Project #: 1009194 Application #: 12DRB-70208
 Project Name: Albuquerque Industrial Park Site
 Agent: James Miller Phone #:

CITY OF ALBUQUERQUE
PLANNING DEPARTMENT
HYDROLOGY DEVELOPMENT SECTION
DEVELOPMENT REVIEW BOARD MEMO

12DRB-70208 Amended Site Plan for
Building Permit

Sheet Title
GRADING & DRAINAGE PLAN
Drawn By: BJ Montoya
Checked By:

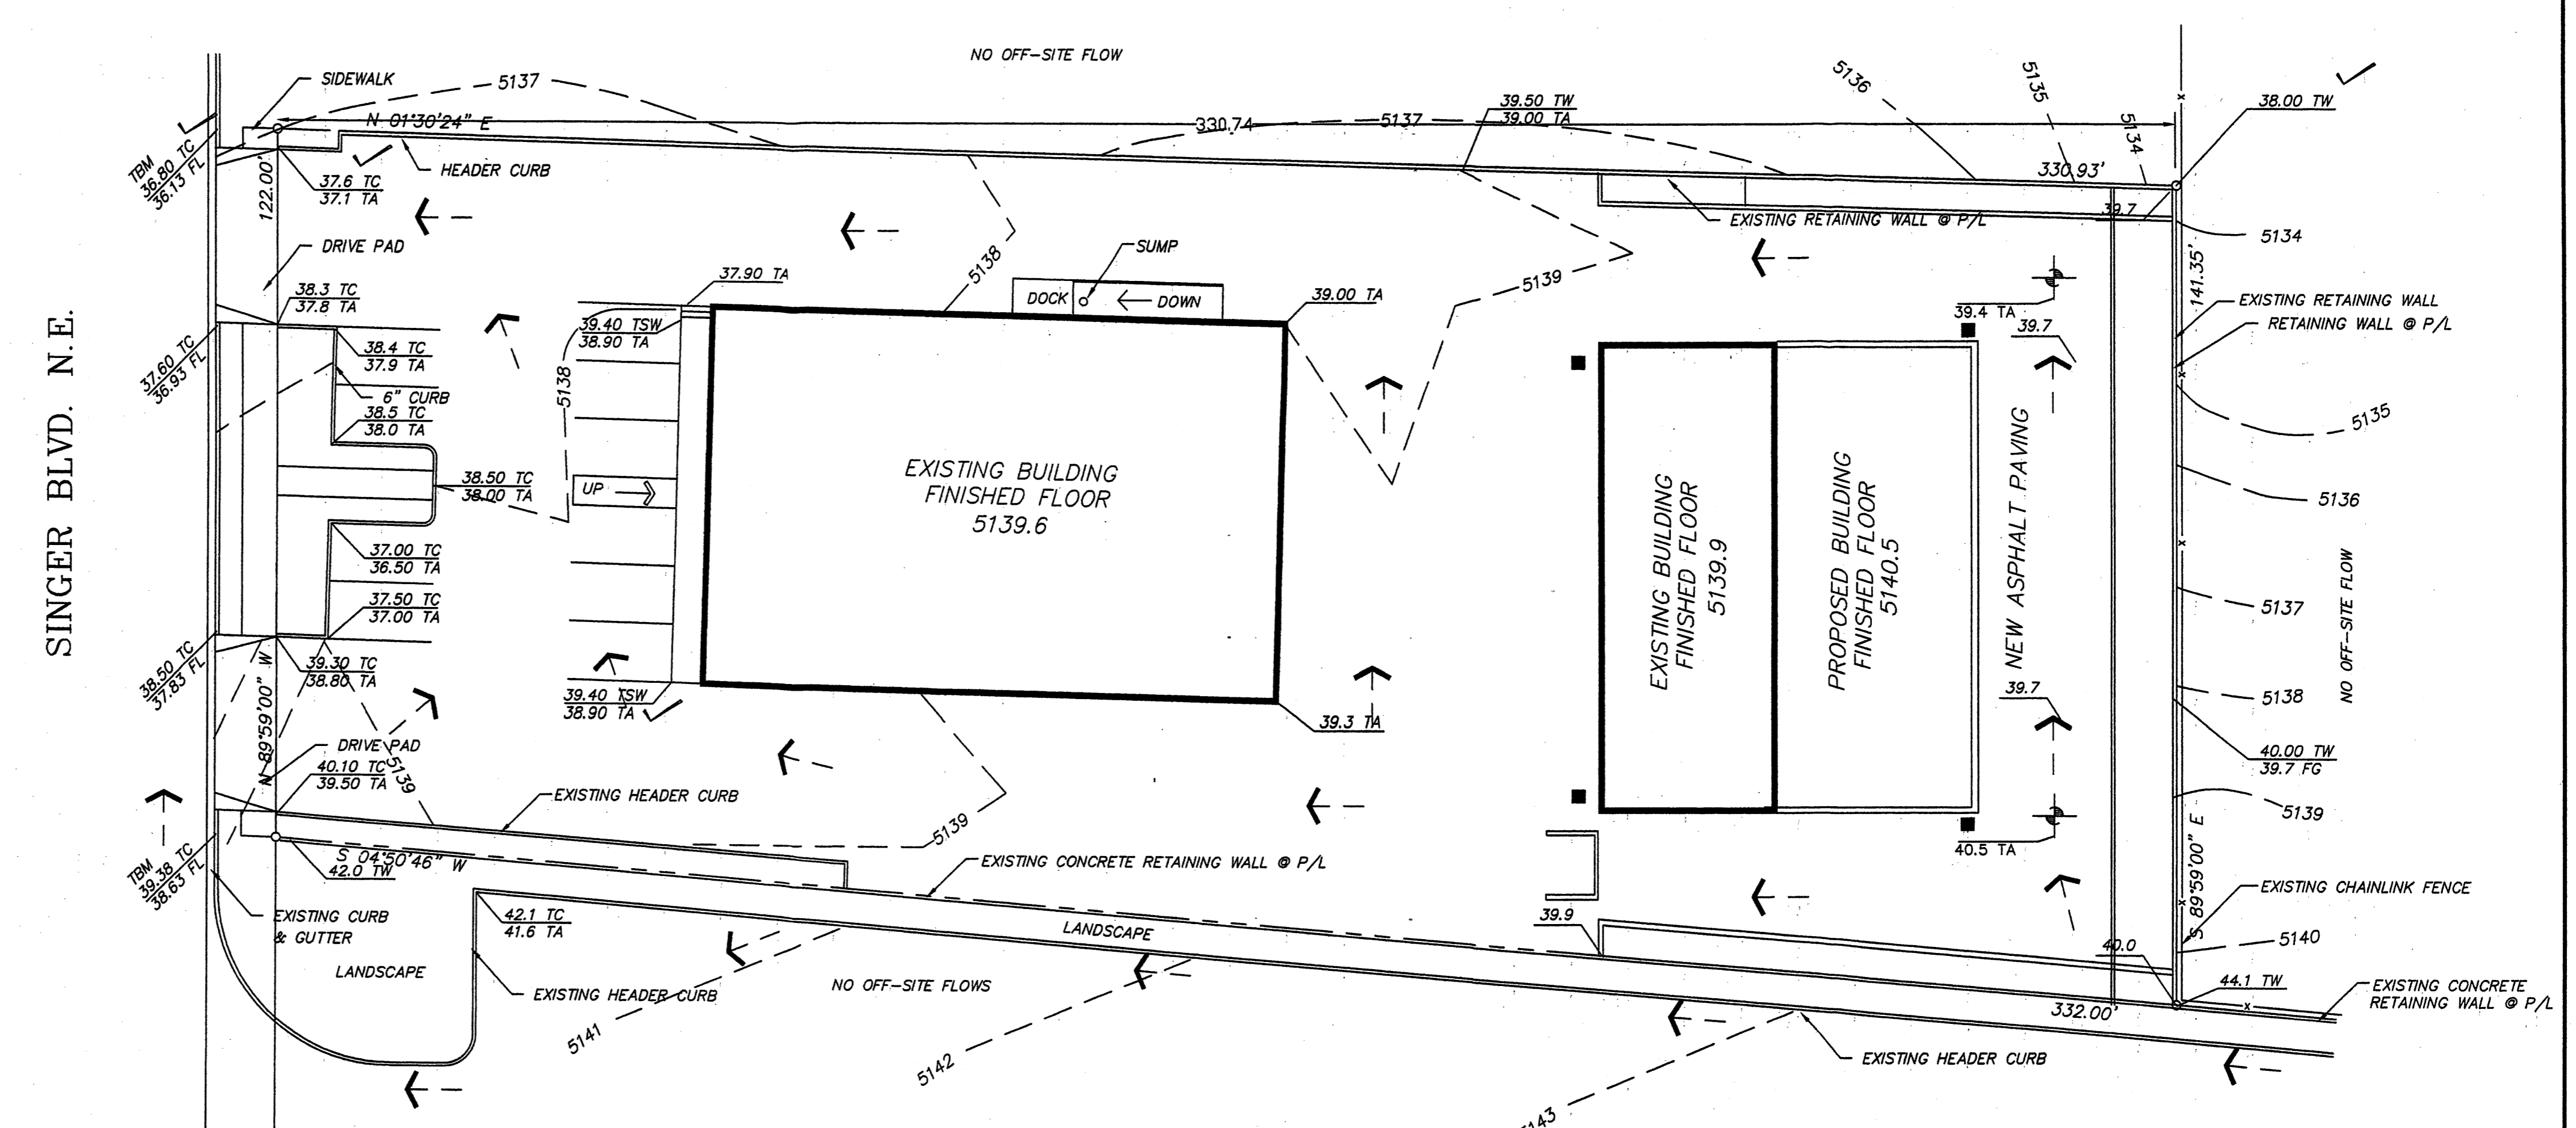
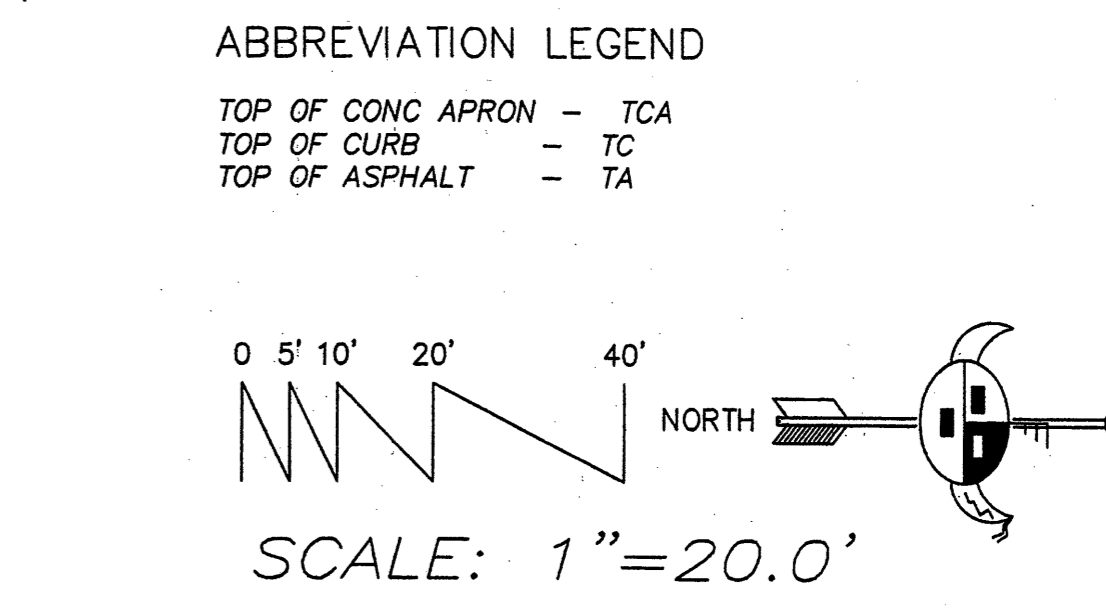
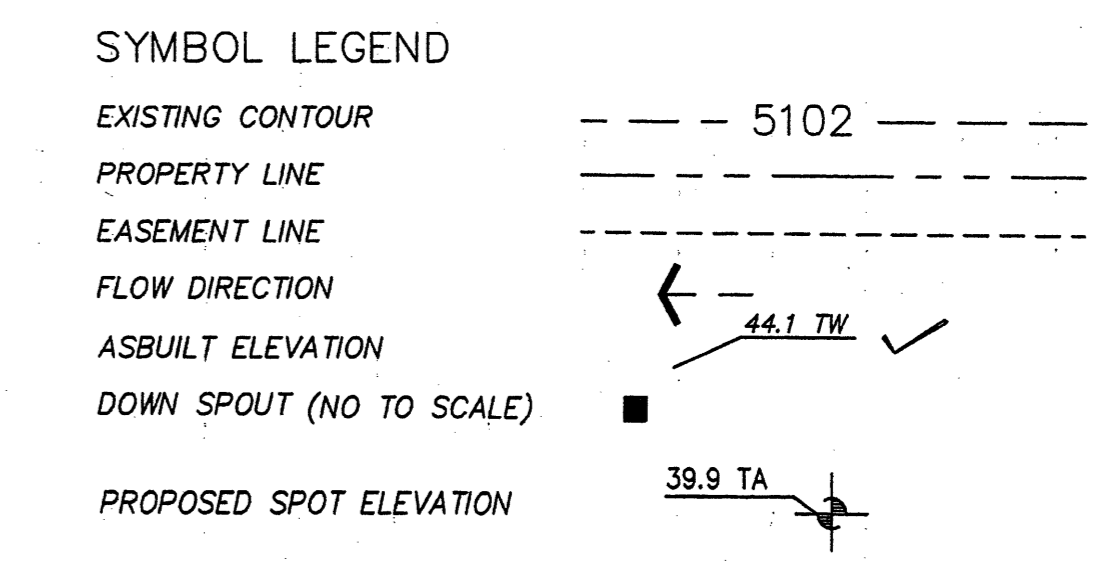
Please include copy of the grading plan with
engineer's stamp date of 07/10/2012 in your Site
Plan for Building Permit set.
